Application Reference: 2026/0451.

Location: 531 Rotherham Road, Smithies, Barnsley, S71 1XG.

This application seeks retrospective planning permission for the erection of a replacement detached outbuilding.

Existing North Western Elevation
Scale 1:50

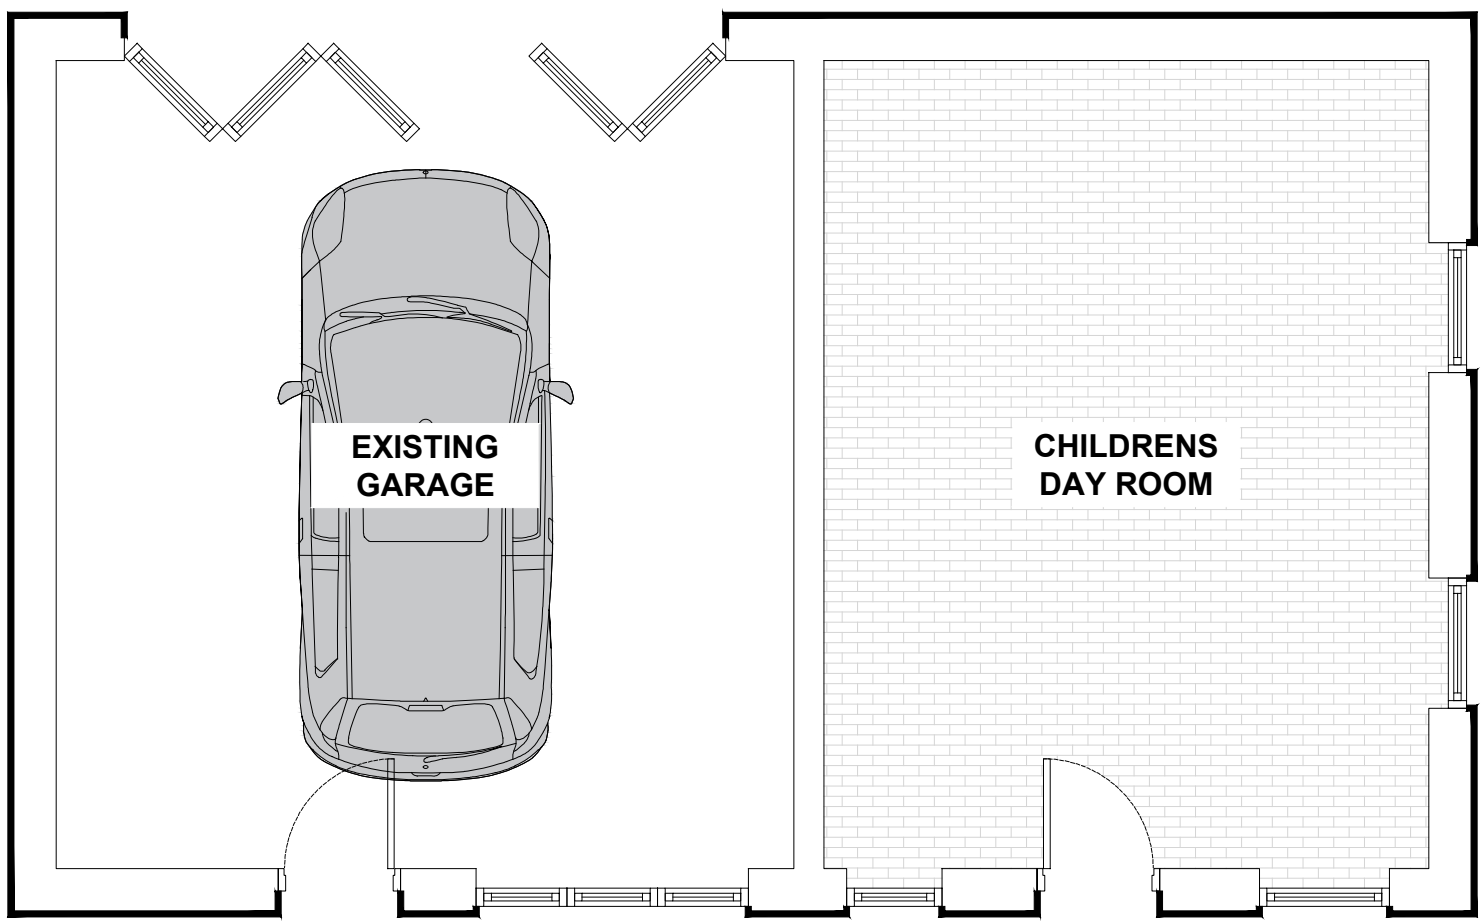
- Confirm the intended use of the children's play room.
- Amend the plans to show render to the north elevation to reflect what exists on-site.

The retrospective detached outbuilding is constructed of red brickwork with an off-white render finish on its north elevation and a rosemary tiled hipped roof.
